PS Redman F.F.A.

9Th May 2013

**Planning Application A/39/13/L and A/41/13
No 5 Longback Cottages Arundel Road Angmering West Sussex**

REAR ELEVATION

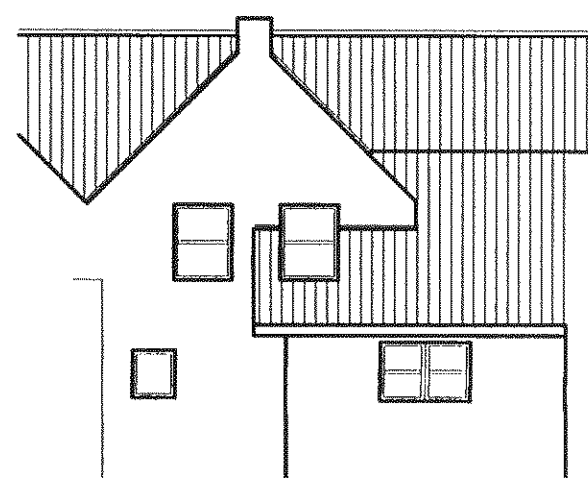
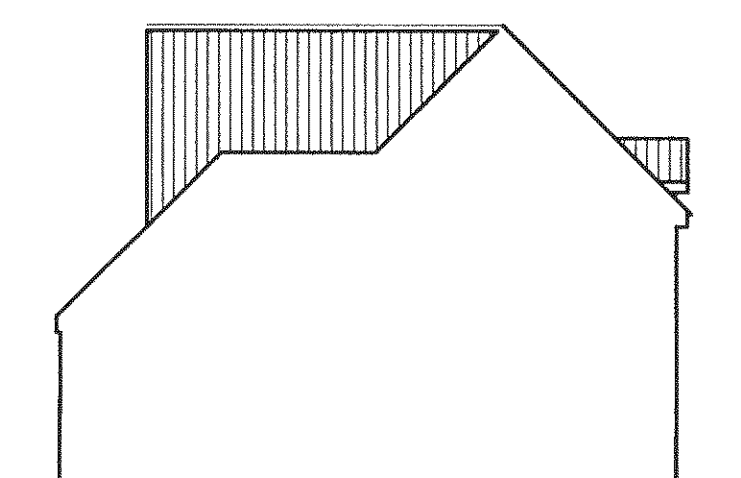
With regards to the grade 11 listed building I am concerned that taking down part of the back wall could cause structural problems to the rest of the cottages in the terrace, we already have strengthening rods in the cottages to stop the bowing of the flint and chalk walls. The walls are very thick in places and the constant hammering to remove part of the walls could cause problems further along the terrace.

GROUND FLOOR

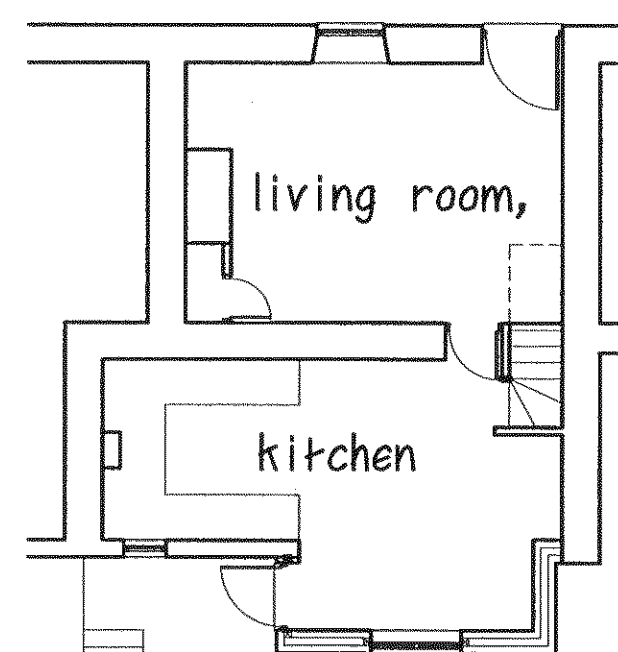
Although most of the cottages have extended out the back they have not taken down part of the original wall but have access from the original back door and the original building has not been damaged.

As far as I am aware we have a shared drainage system which runs along the back of the cottages close to the building, I believe that these drains are quite old, and any foundations in that area could affect the drains to the whole terrace.
